From: Simon Davis
Sent: 19 July 2019 16:51
To: Planning.Responses
Subject: FW: Application Ref. Y/48/19/DOC, Seeking the Discharge of Conditions 9 and 10 of Outline Consent Ref. Y/5/17/OUT - Land at the Former Cinders Nursery, Cinders Lane, Yapton, BN18 0JJ
Attachments: 19.14.102 E Site Wide Elements.pdf; 020.0096.013.A.pdf
Importance: High

Subject: Application Ref. Y/48/19/DOC, Seeking the Discharge of Conditions 9 and 10 of Outline Consent Ref. Y/5/17/OUT - Land at the Former Cinders Nursery, Cinders Lane, Yapton, BN18 0JJ
Importance: High

From: Tim Townsend [REDACTED]
Sent: 17 July 2019 09:33
To: Simon Davis [REDACTED]
Cc: Rob Torrance [REDACTED]
Subject: Cinders Lane DOC app - further information

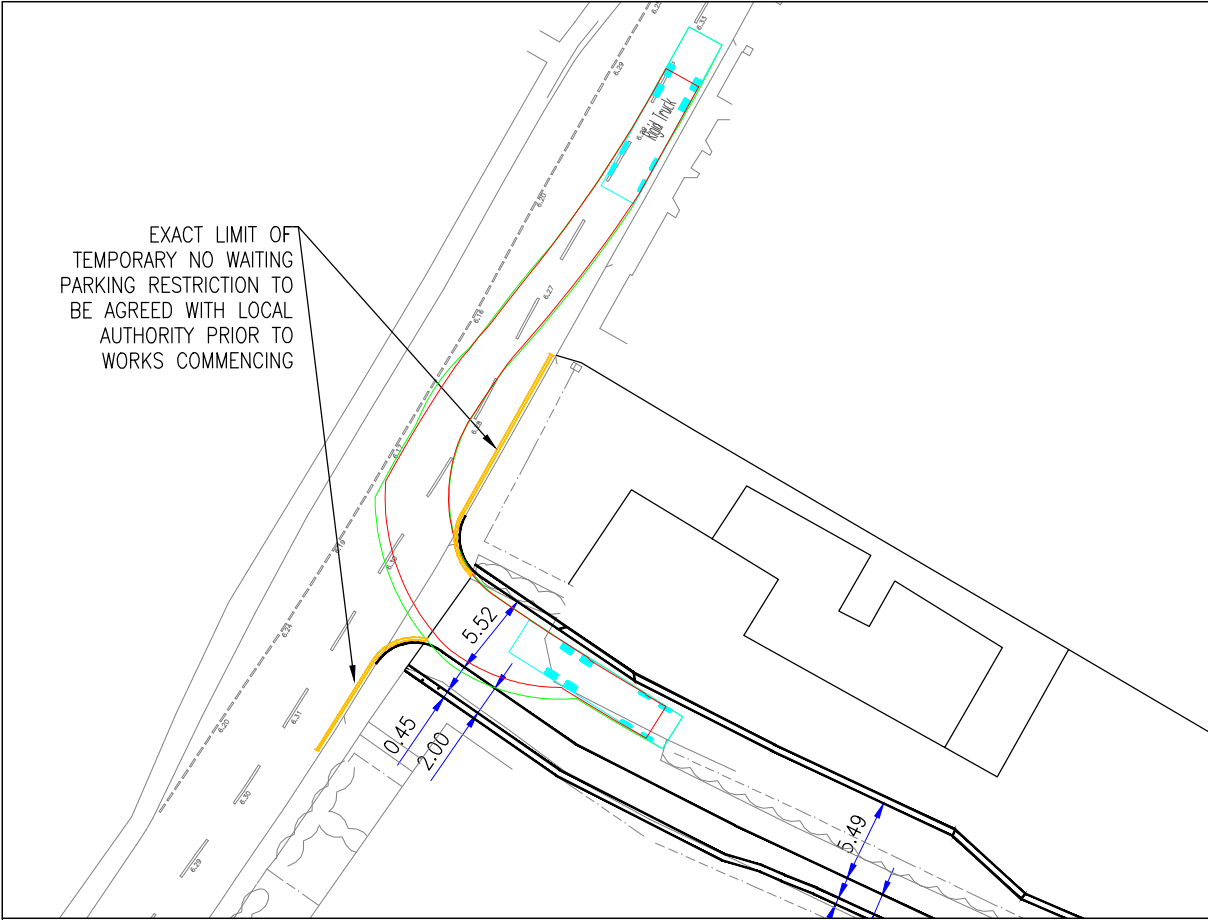
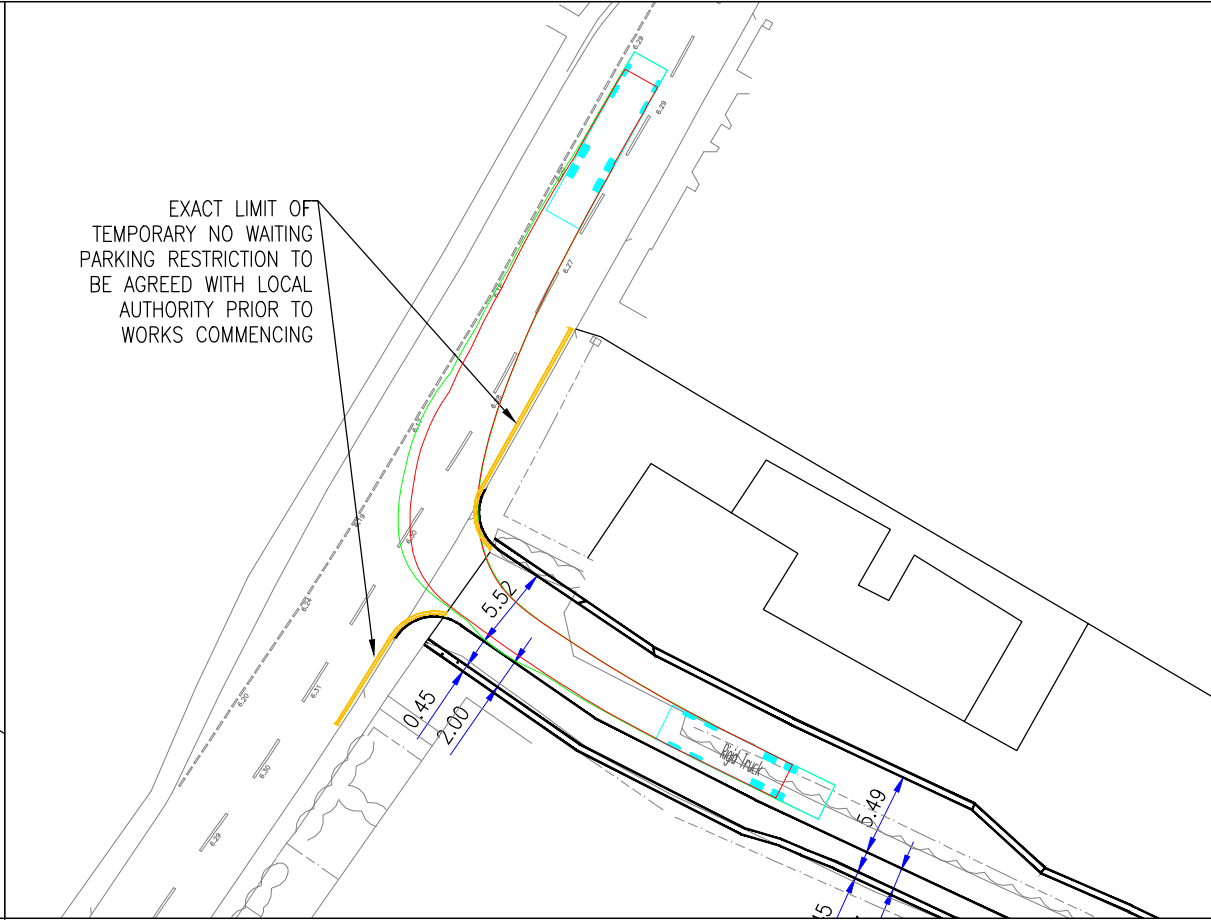
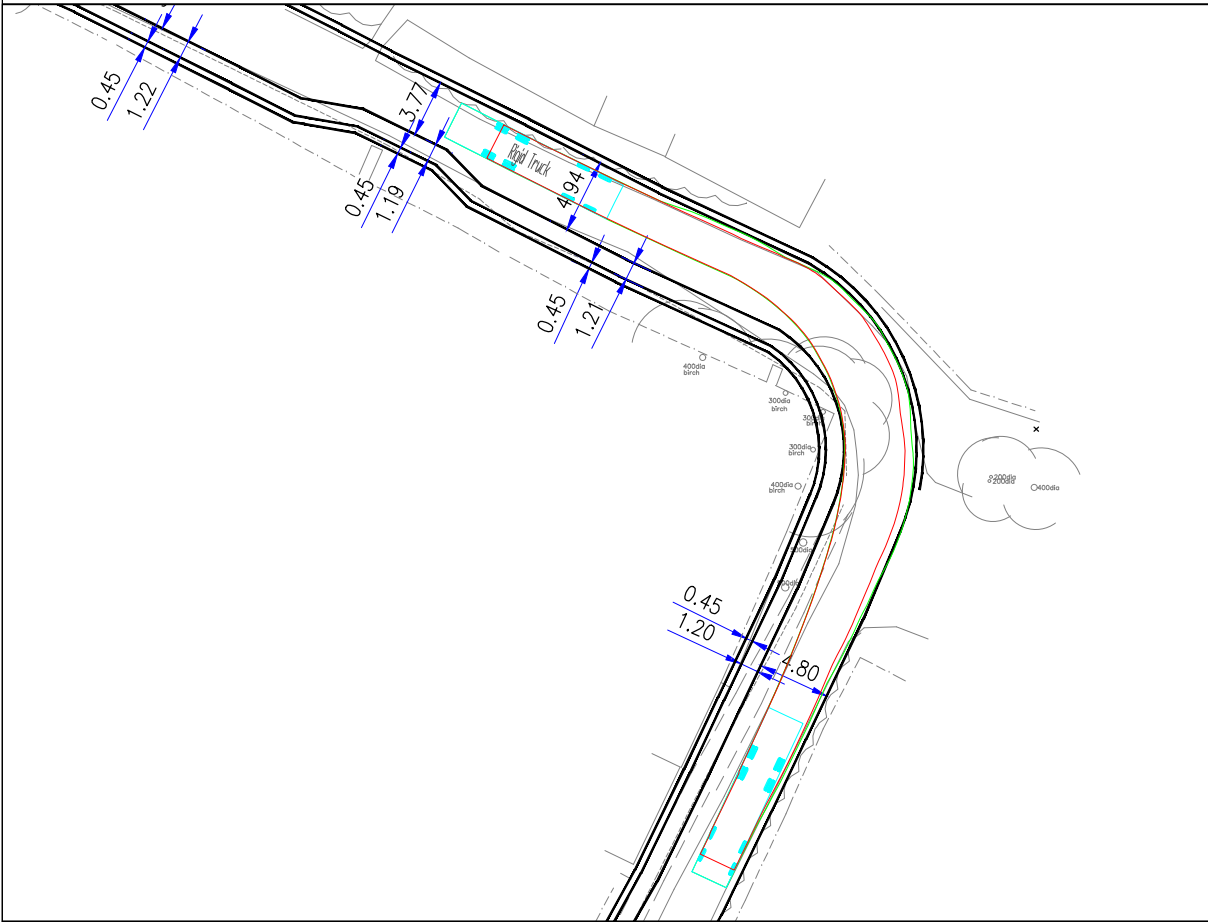
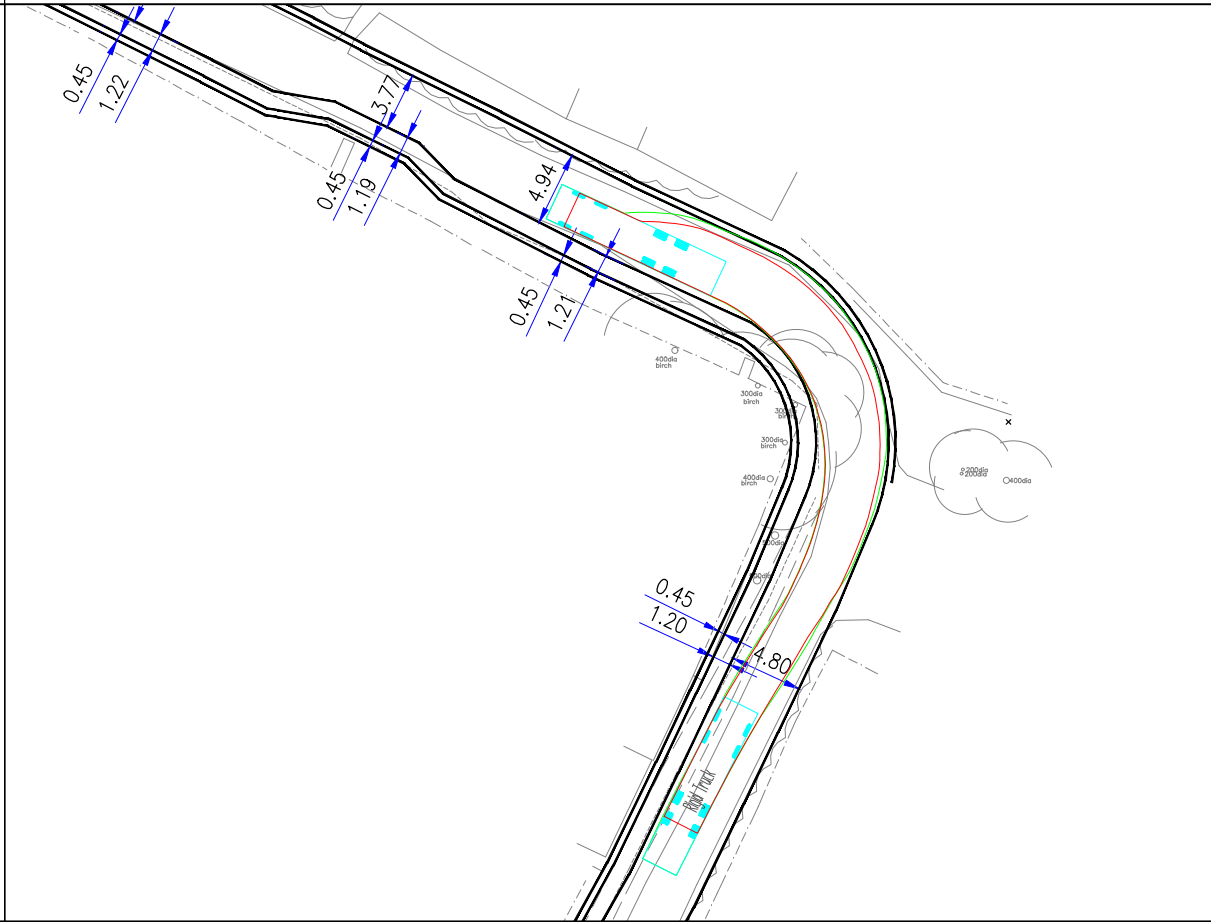
As I have already said, it does appear that temporary waiting restrictions will be required to ensure that large vehicles are able to gain access to and egress from Cinders Lane. The tracking diagrams show that they are needed to the north of the junction, though maybe not for the 25 metre length indicated in the diagram (15m would probably be adequate) and I would suggest that the markings should extend southwards far enough to cover the driveway of 8, Medway Cottages, to ensure that the full width of Cinders Lane is kept clear, so about 6 or 7 metres. However, final details will need to be agreed on-site with the Traffic Officer prior to any works commencing.

County considers that it would be unreasonable to prohibit waiting outside the shop to the north of this junction for the duration of the works, which means that the inevitable presence of parked vehicles will require lorries approaching the site to straddle the centre line of the B2132 Bilsham Road for 40 – 50 metres before reaching the junction. The carriageway is not wide enough to accommodate 2-way traffic as well as the parked cars, so northbound traffic will not be able to pass lorries in this position, so there is a strong likelihood of congestion arising from these local traffic conditions (although congestion does arise here fairly regularly already because of parked vehicles). It is noted that the CMP provides for 2 banksmen to be available in the event that a lorry is required to reverse off site. However, WSCC would like this extended in order to enable lorries to turn into Cinders Lane from the B2132, requiring appropriately qualified people (e.g. banksmen) to be equipped with STOP/GO or STOP WORKS signs, so that traffic can be controlled if conditions require it.

Further to our recent exchange of emails below, please find attached a revised Site Wide Elements Plan ref. 19.14.102 rev. E and accompanying revised tracking diagram ref. 020.0096.013 rev. A, in respect of condition 9 of the site's outline consent ref. Y/5/17/OUT. The notes set out on the Site Wide Elements Plan have been revised to cover the TTRO and the banksmen, as per the request set out in the email dated 17 July 2019 from WSCC Highways – the precise details of the TTRO can be agreed in due course; and my client's highways consultant has been instructed to proceed immediately with an application for the TTRO.
